From: Simon Davis
Sent: 22 October 2019 11:30
To: Planning Scanning
Subject: FW: 34 Wakefield Way AW/246/19/PL

From: Simon Davis
Sent: 22 October 2019 11:29
To: 'Ivon Blumer' [REDACTED]
Subject: RE: 34 Wakefield Way AW/246/19/PL

From: Ivon Blumer [REDACTED]
Sent: 21 October 2019 10:14
To: Simon Davis [REDACTED]
Subject: 34 Wakefield Way AW/246/19/PL

Site Plan

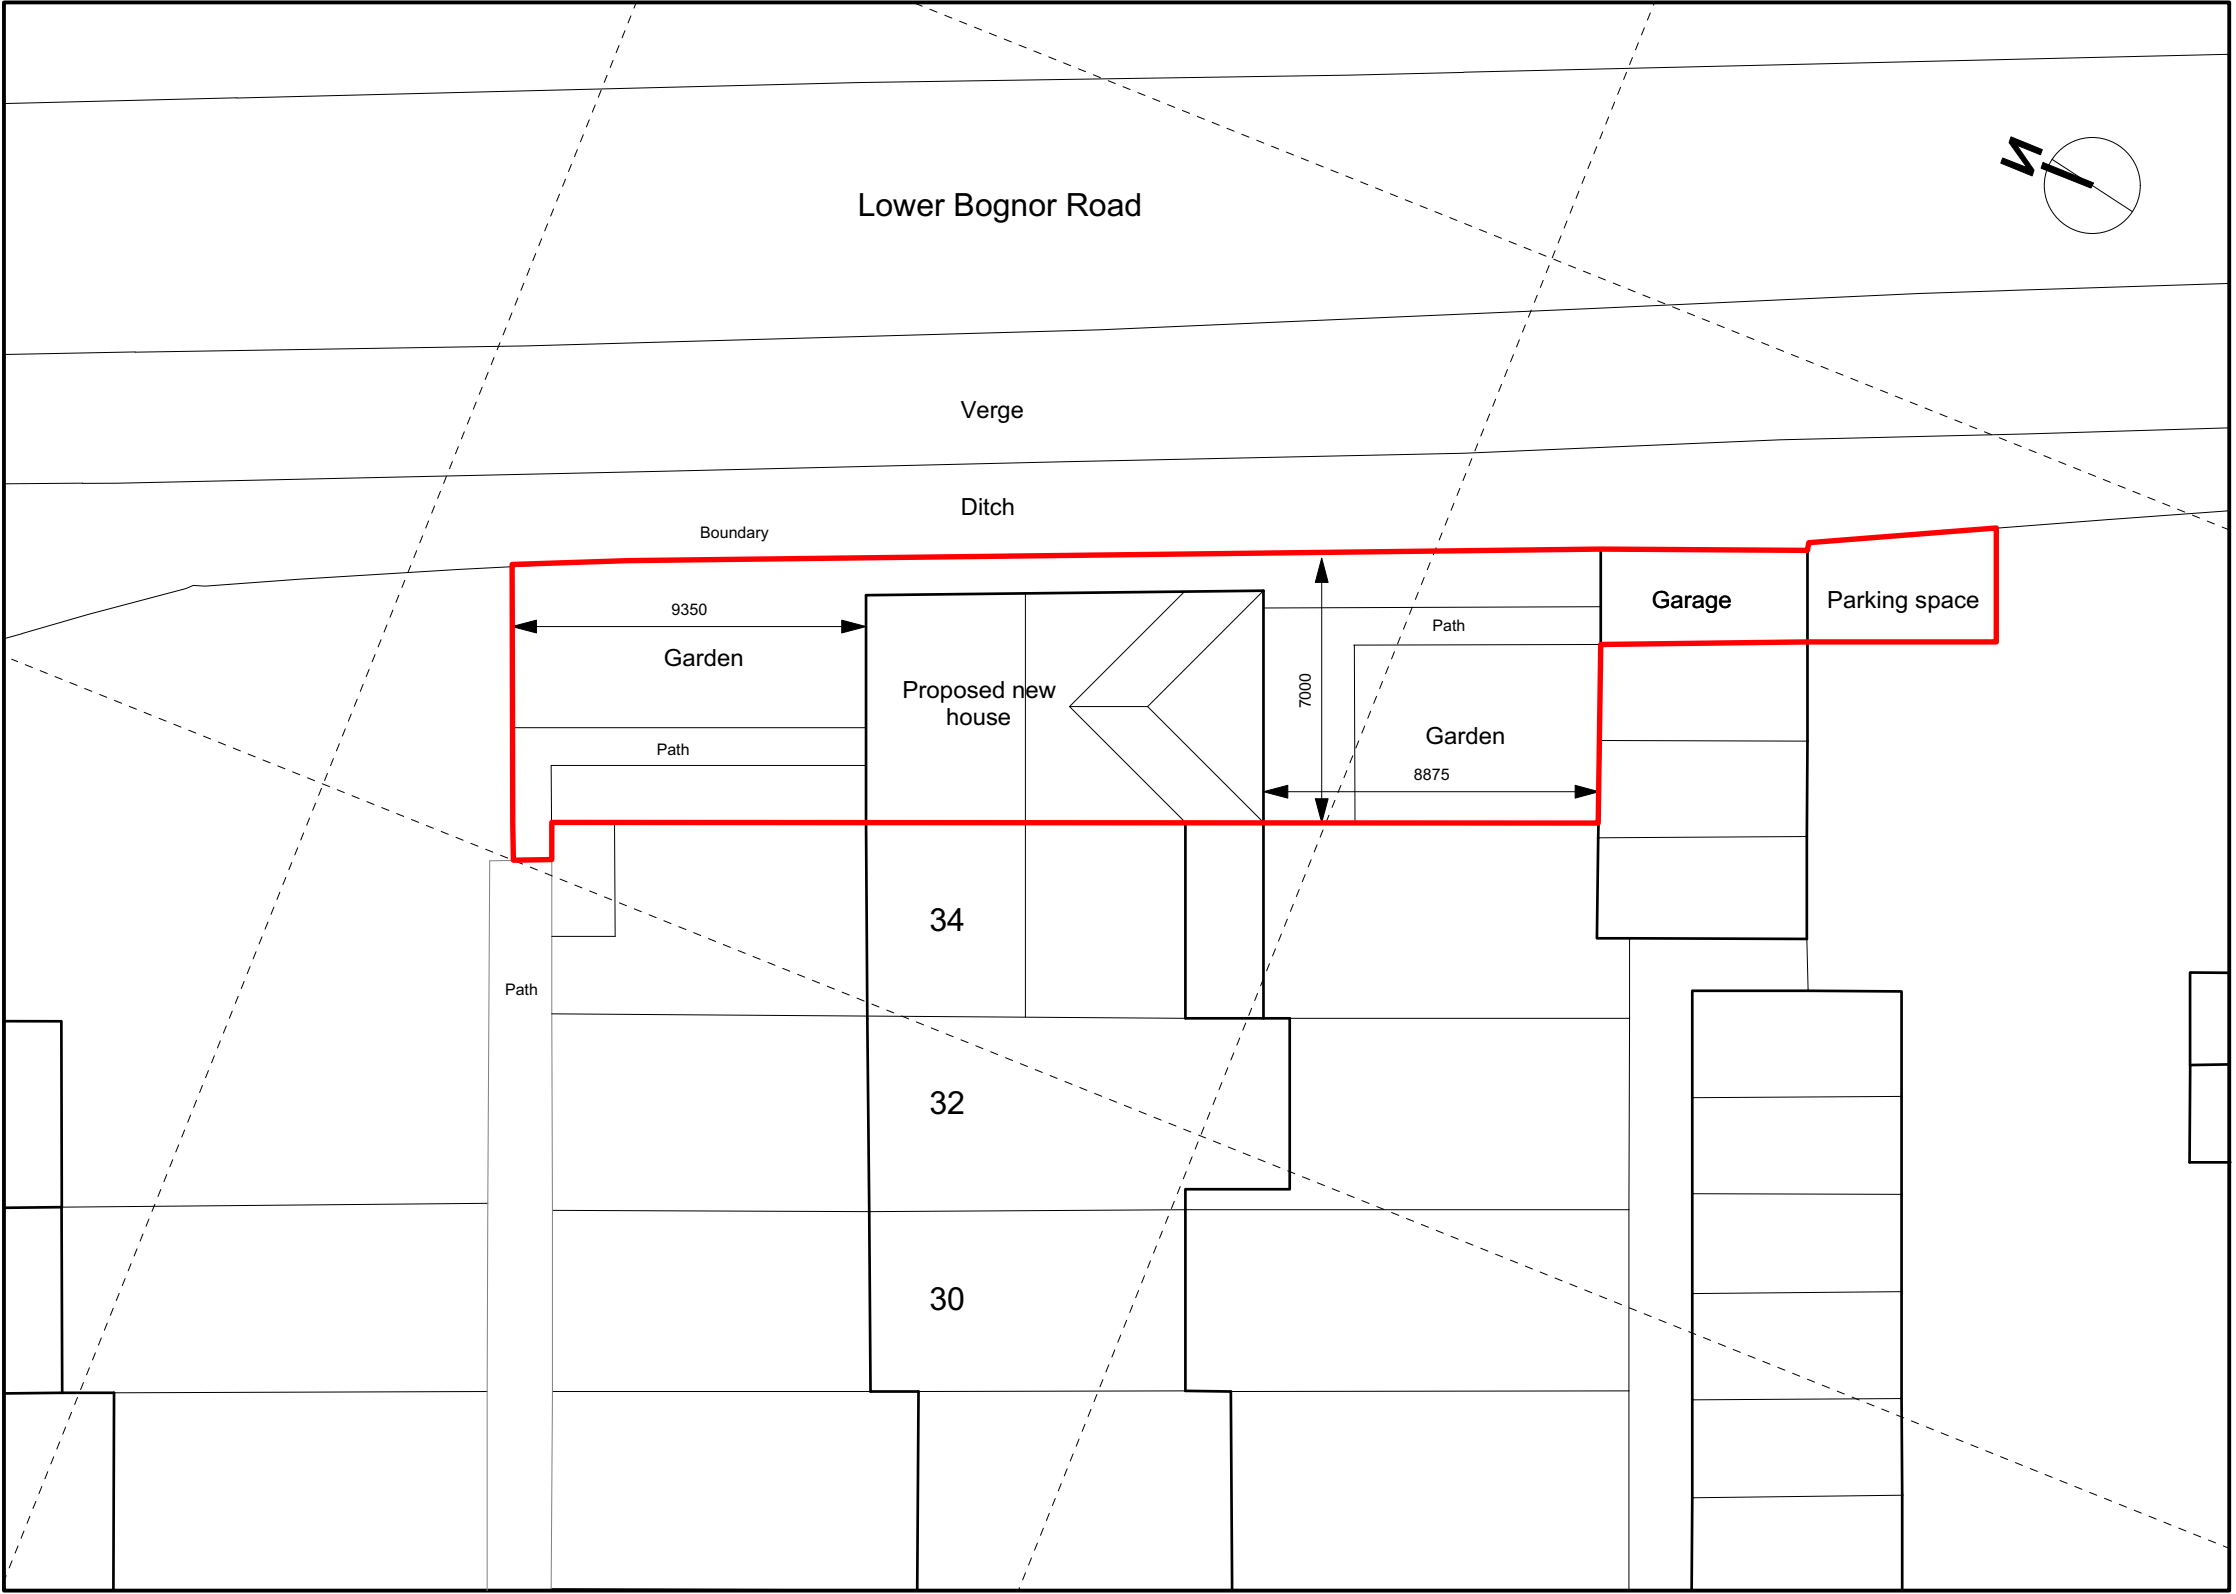
I have discussed this morning with my Team Leader and we are prepared to support the proposal in terms of principle/design/amenity/parking. However, can you confirm that all of the land in your red edge is owned by your client (I am curious regarding the section of the red edge to the front of the garage).

In addition, I do have concerns regarding the impact of the new house on the root protection areas of the existing trees to the east. I have spoken with our Tree Officer and he recommends that you employ the services of an Arboricultural Consultant to carry out a tree survey exercise and then prepare an Arboricultural Implications Assessment (AIA) which must be inclusive of; a 'Tree Survey Schedule', a 'Root Protection Area (RPA) Schedule' and a 'Tree Constraints Plan' - with the trees accurately plotted on same. Also, in the event that a RPA of any tree which is proposed for retention overlaps the development then BS5837:2012 requires that the Detailed Planning Application is accompanied by an Arboricultural Method Statement (AMS) and also most importantly a Tree Protection Plan - to both describe and illustrate the mitigation measures which are to be employed to ensure that the trees survive without detriment to their vigour and vitality and are given adequate protection both above and below ground. If you are unable to provide this, then it is likely that our Tree Officer will recommend objection.
